Application no: **3/2022/0619**

Address: **Water Tank and Valve House off Vicarage Lane Wilpshire BB1 9HY**

Proposal: **Conversion of redundant water tower and valve house to create a single dwelling to include the creation of a short access track.**

The Local Highway Authority have viewed the plans and highway related documents and have the following comments to make:

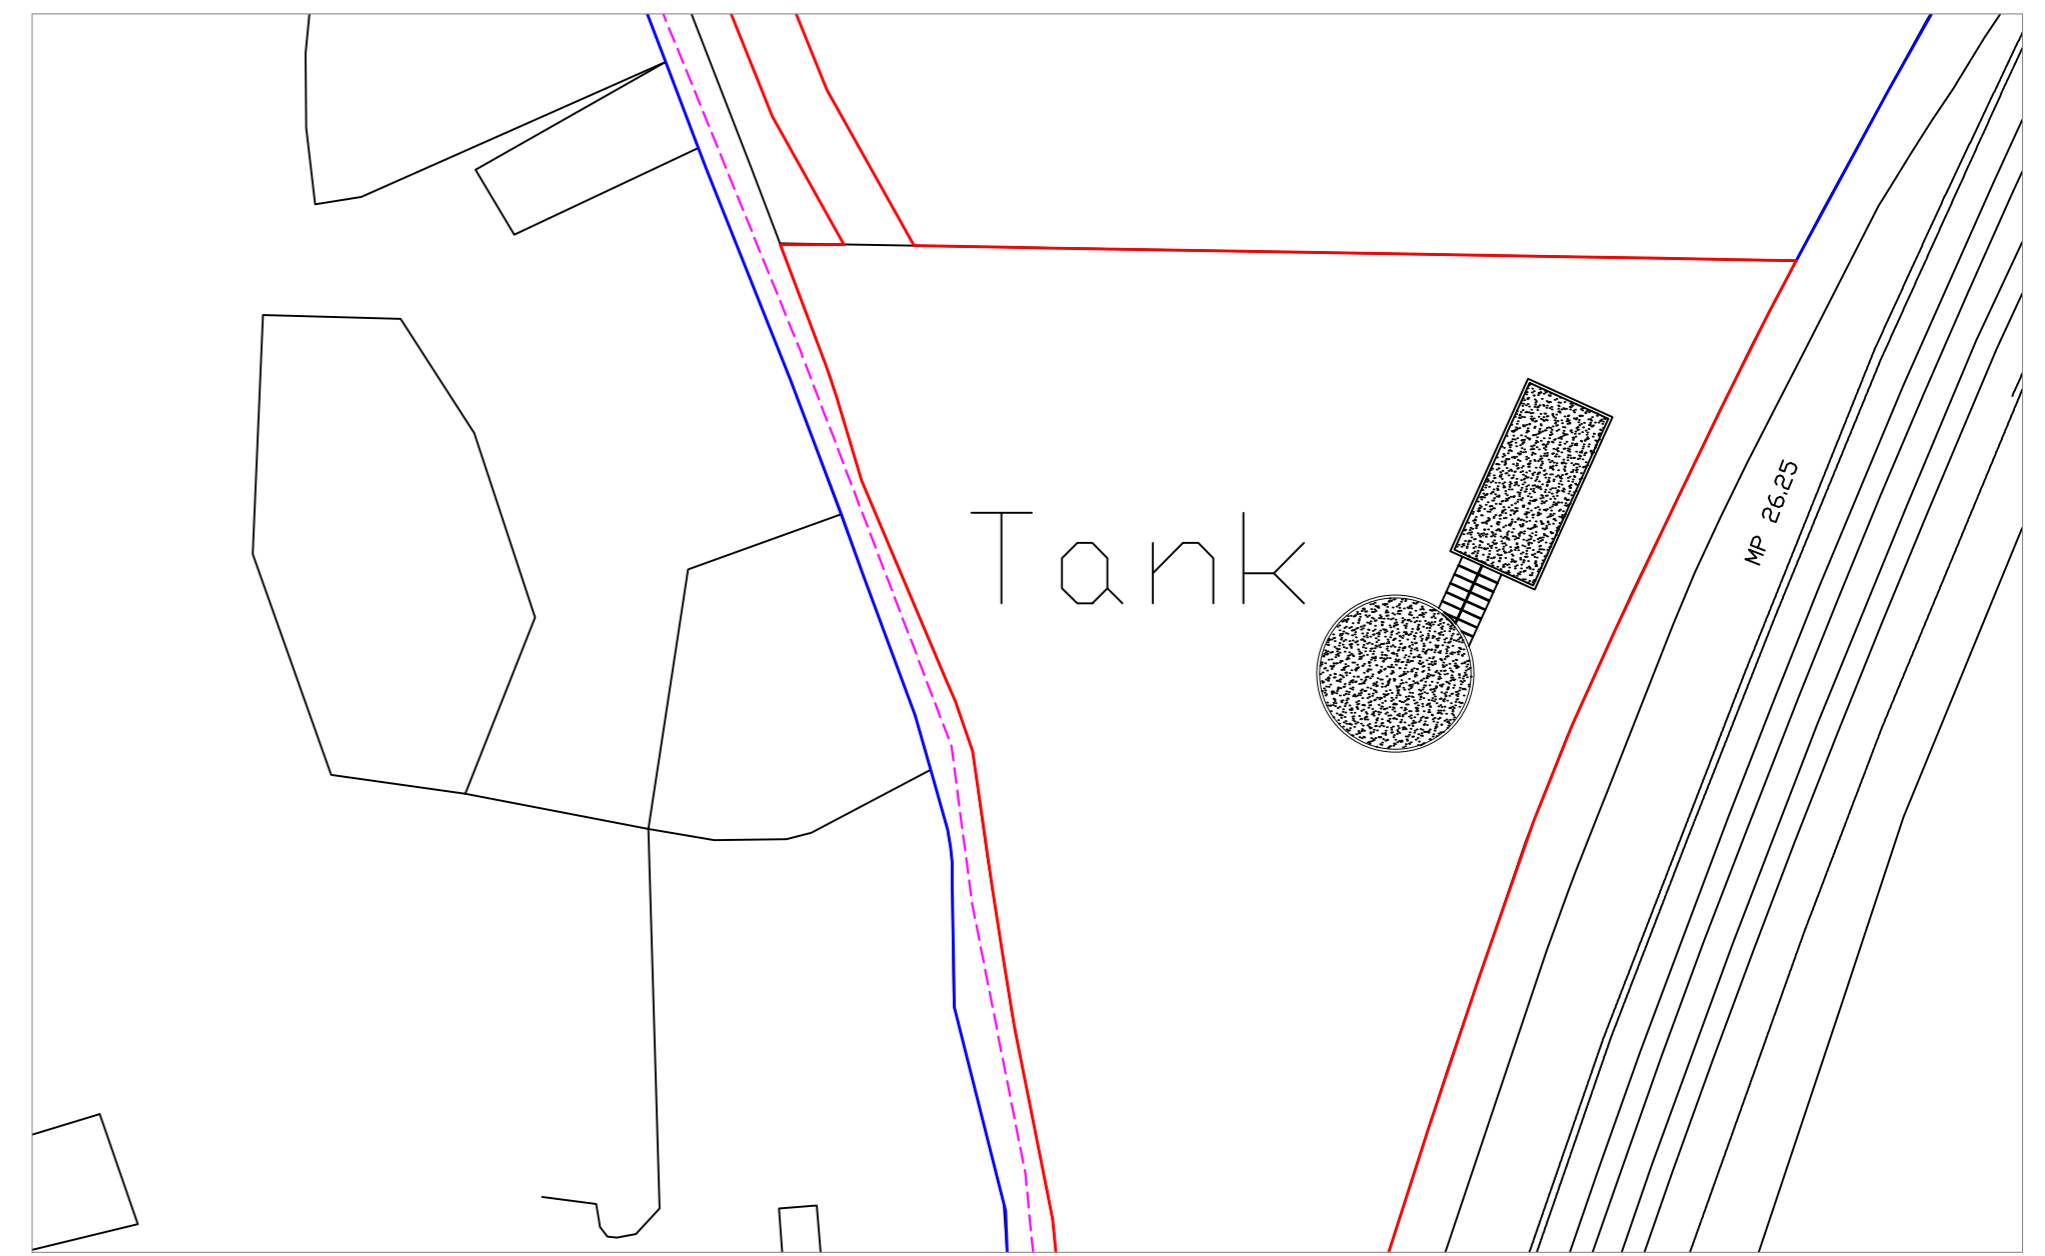
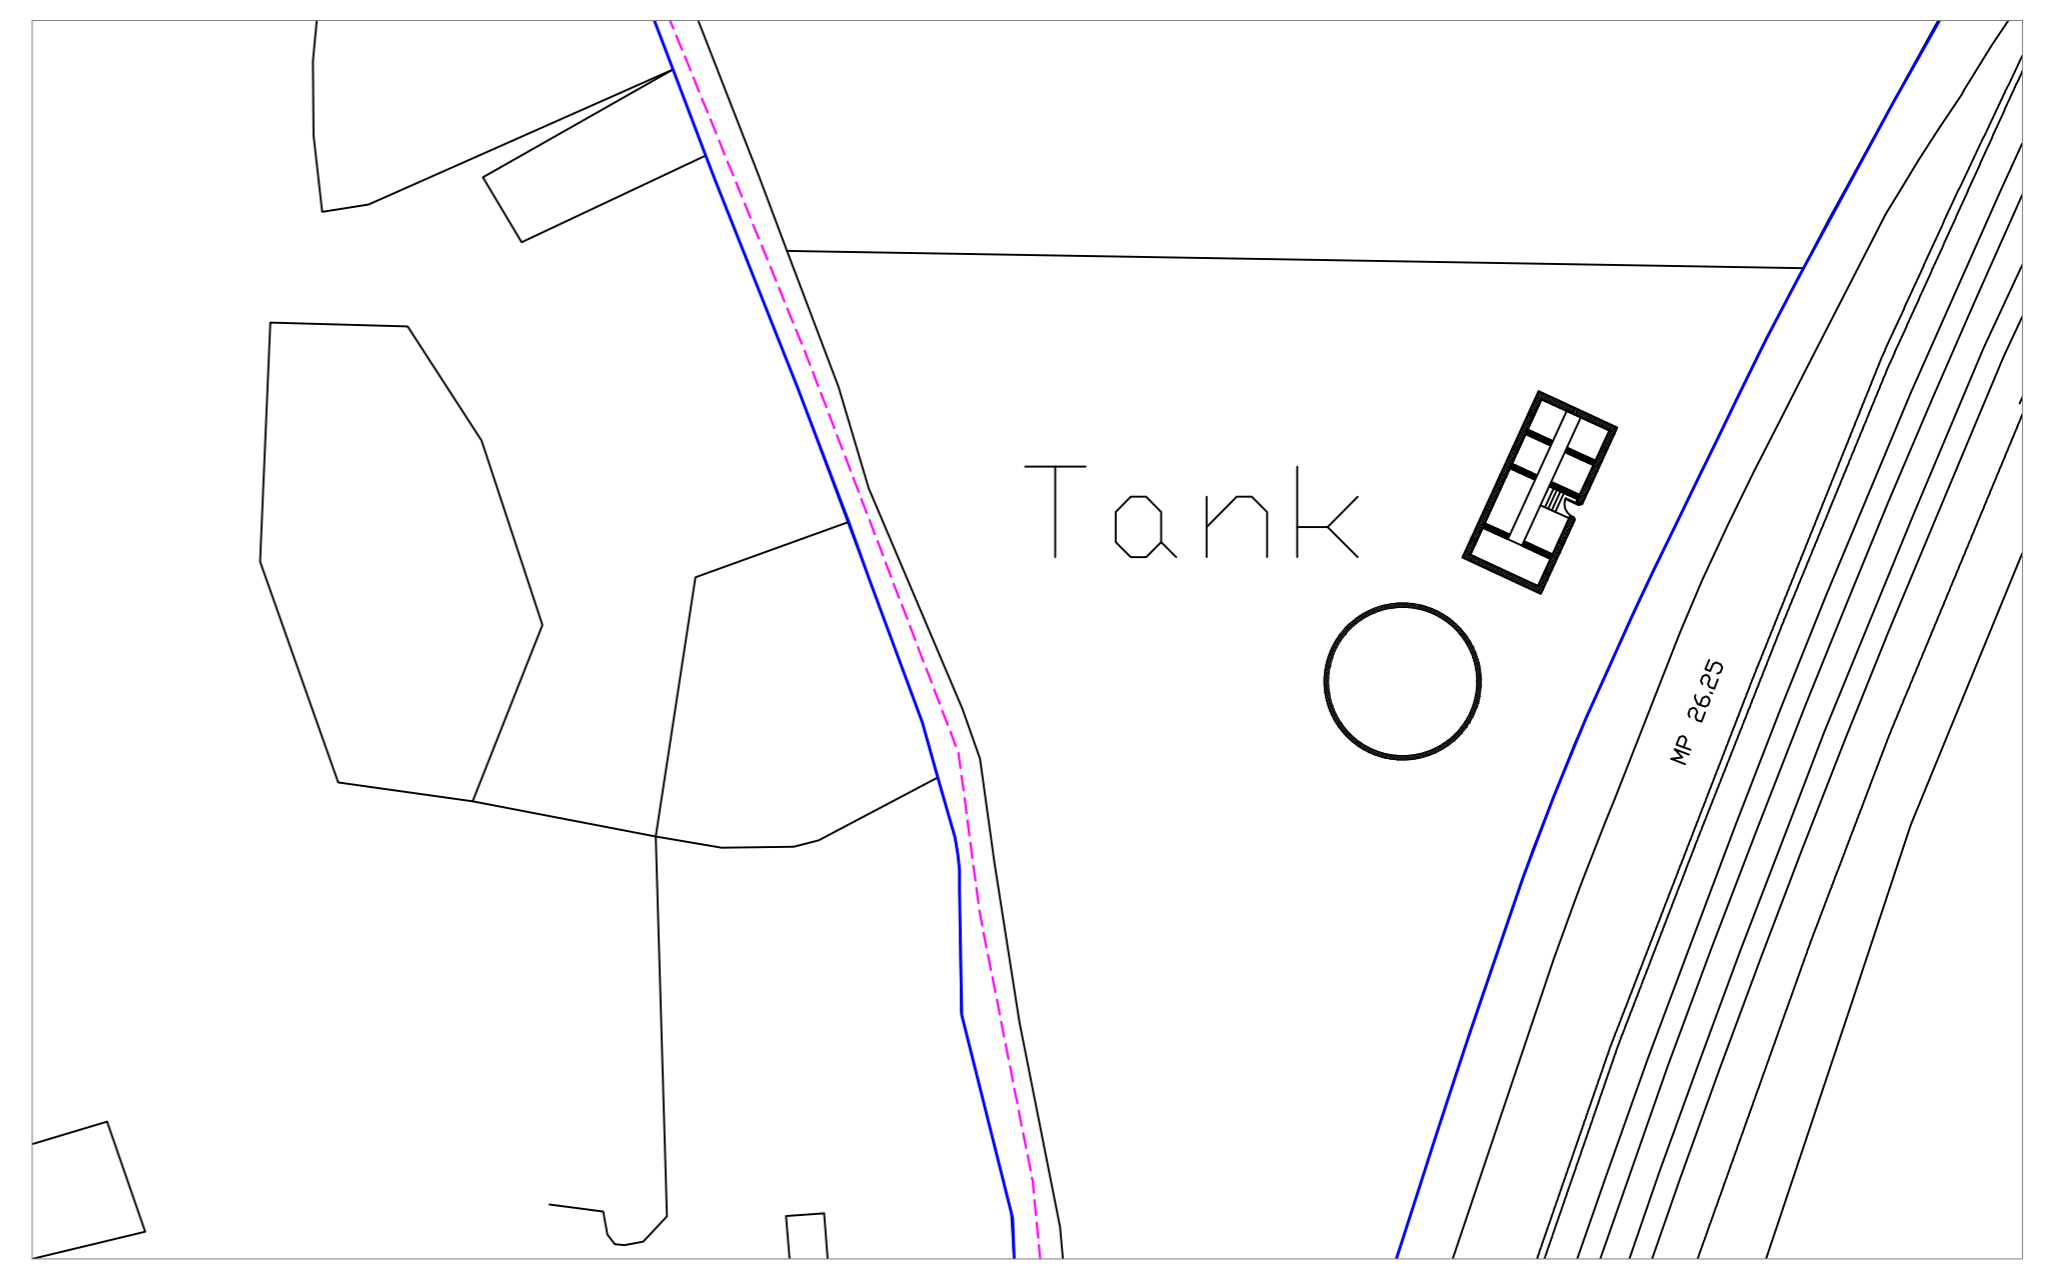
Despite this, the LHA will request that 2 passing places are implemented along the track, with each passing place measuring 2.5m wide and 15m in length. The LHA require this because the track will serve both residential and as an agricultural use. Therefore, following the proposal more traffic will use the track, meaning that there is a higher chance that vehicles will meet along it. Due to this, the LHA require passing places to be implemented to ensure that two-way movements can occur along the single track. The LHA require these passing places to be shown on a revised drawing.

The LHA require a revised drawing showing that two passing places are implemented along the agricultural track which will serve the proposed dwelling. Should the amended drawing comply with the LHAs guidance, the LHA will have no objection to the proposal.
